# DRB CASE ACTION LOG (PREL & FINAL)

DRB Application No.: <b>07DRB-70074 (P&amp;F)</b>	Project # <b>1006564</b>
Project Name: <b>HERRERA SUBDIVISION</b>	
Agent: <b>SURVEYS SOUTHWEST</b>	Phone No.: <b>998-0303</b>

**CITY OF ALBUQUERQUE  
PLANNING DEPARTMENT  
June 27, 2007  
DRB Comments**

**RE: Tracts 1-B & 1-C, Herrera Subdivision/p&f**

**PLAT OF  
TRACTS 1-B-1 & 1-C-1  
HERRERA SUBDIVISION  
PROJECTED SECTION 32, T. 11 N., R. 3 E., N.M.P.M.  
ELENA GALLEGOS GRANT  
CITY OF ALBUQUERQUE  
BERNALILLO COUNTY, NEW MEXICO  
JUNE 2007  
SHEET 2 OF 2**

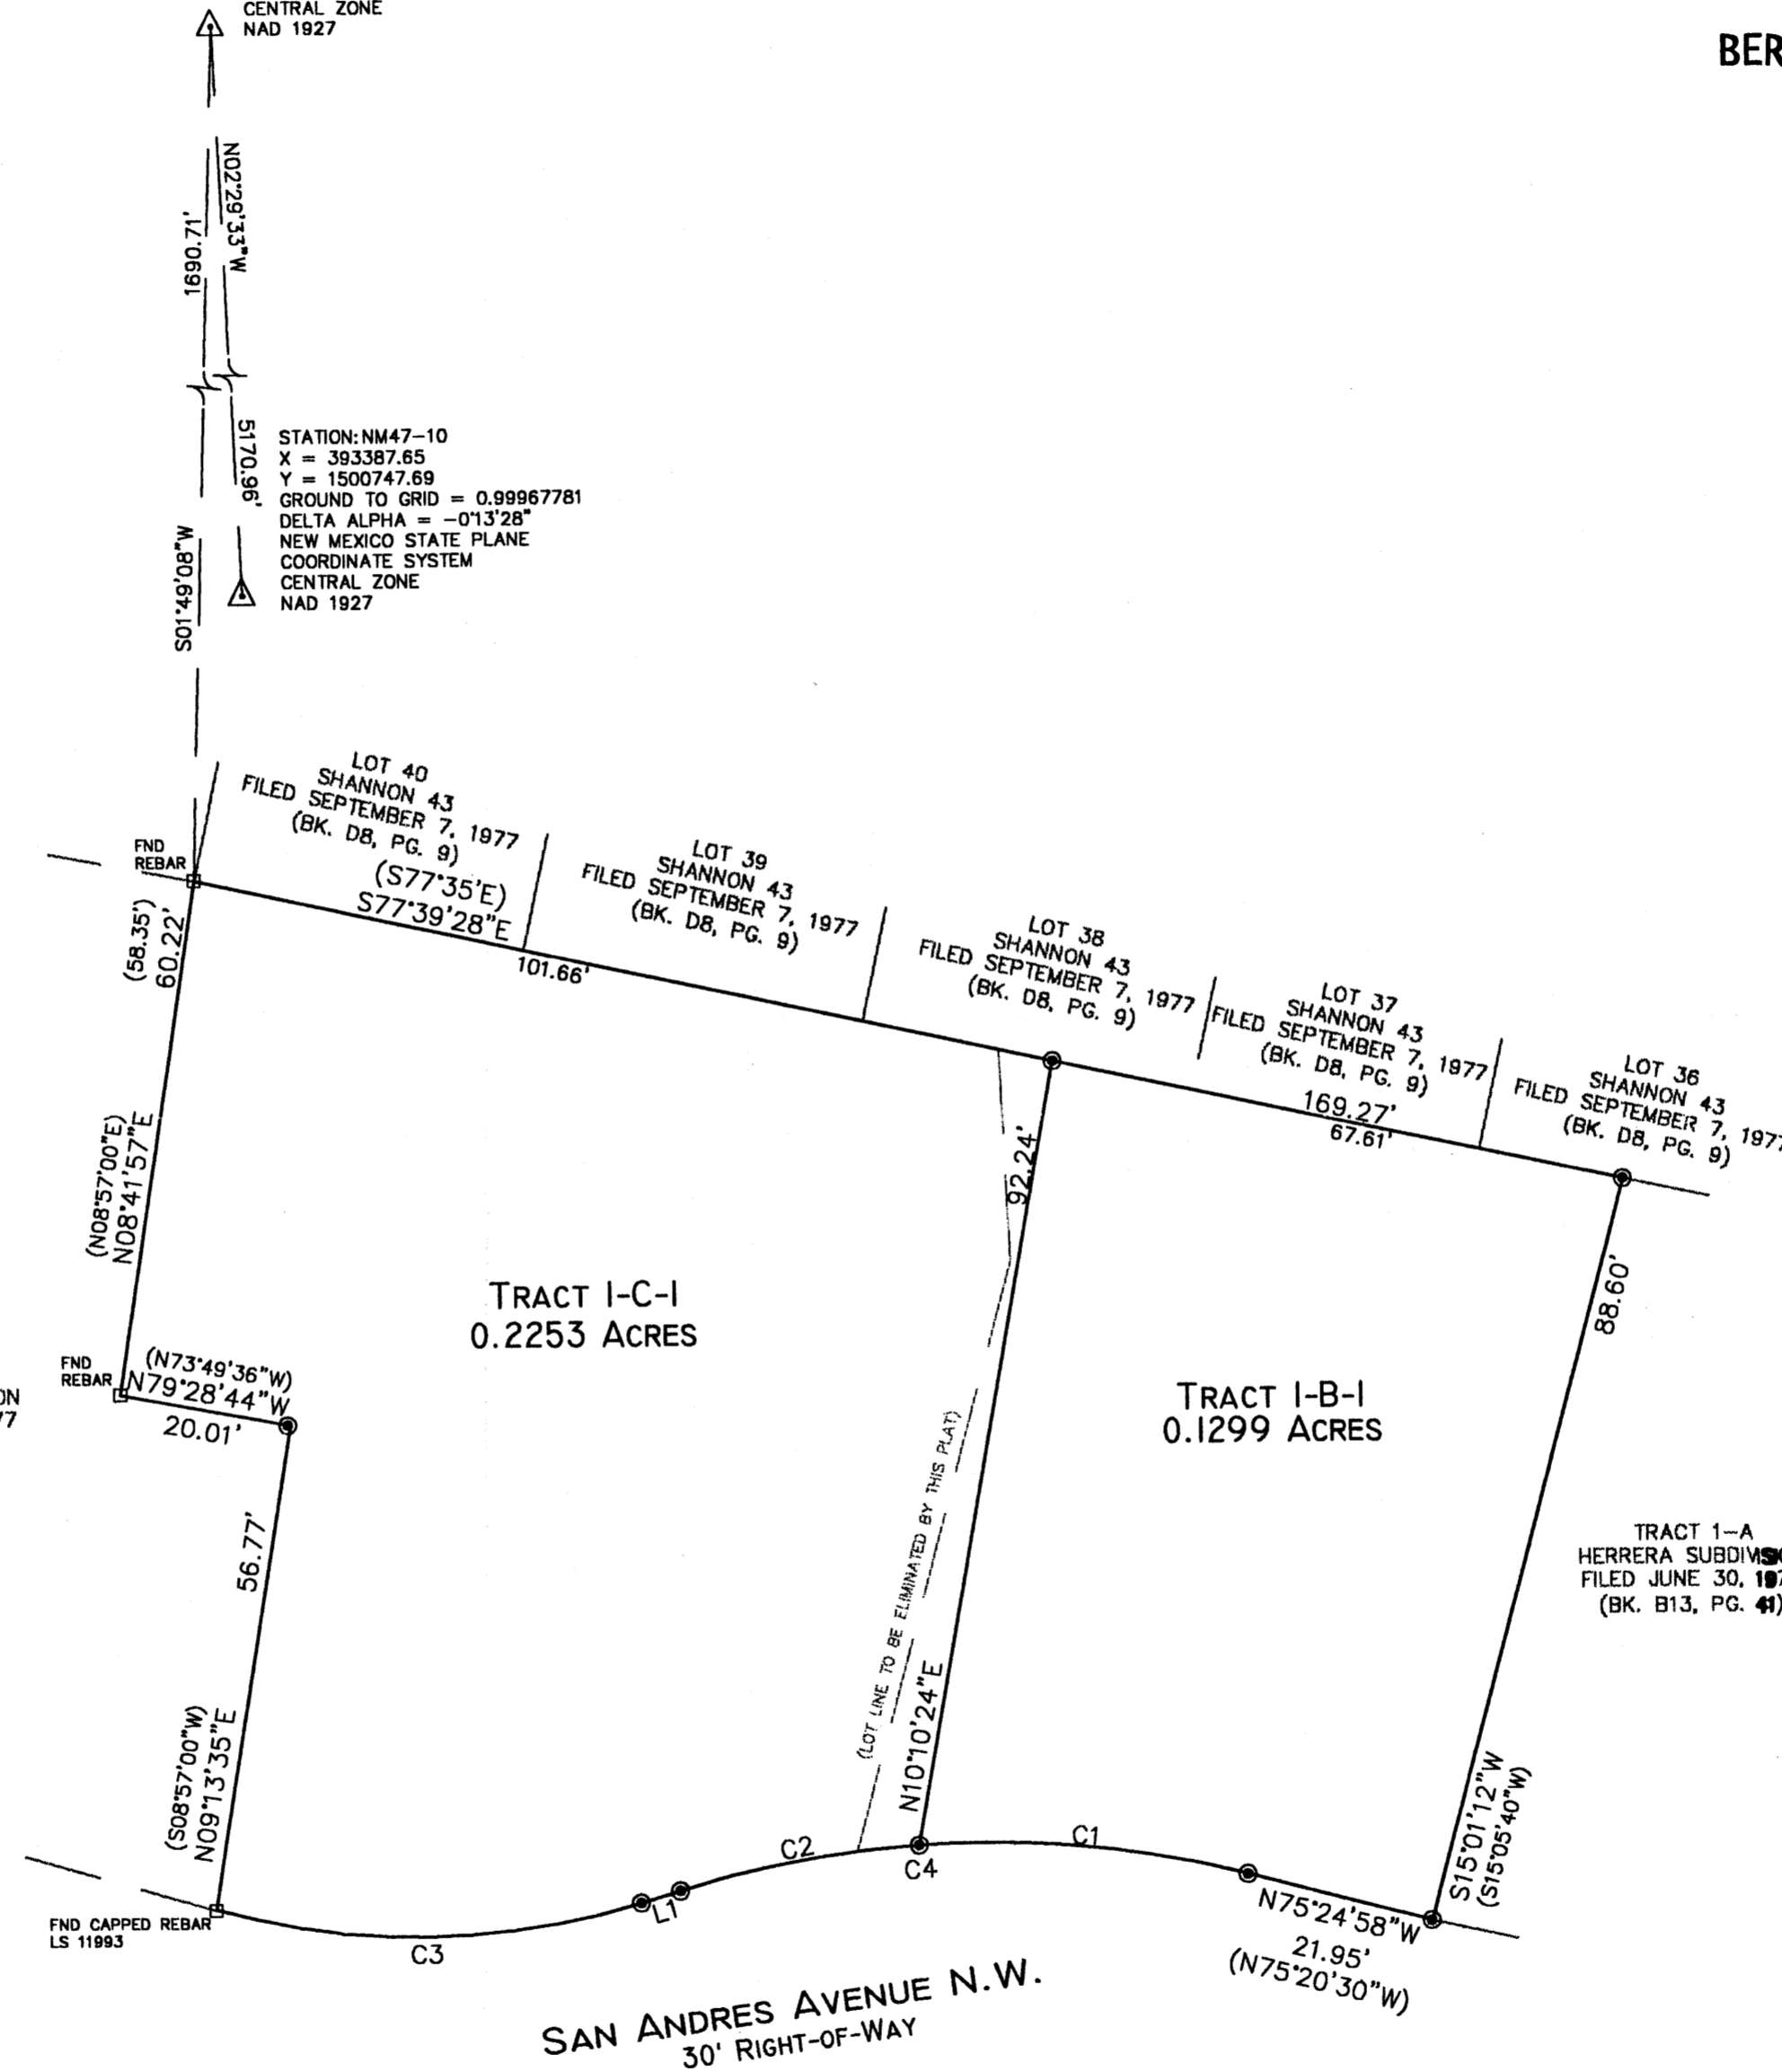
TRANSPORTATION: X DEDICATION FOR S.WALK
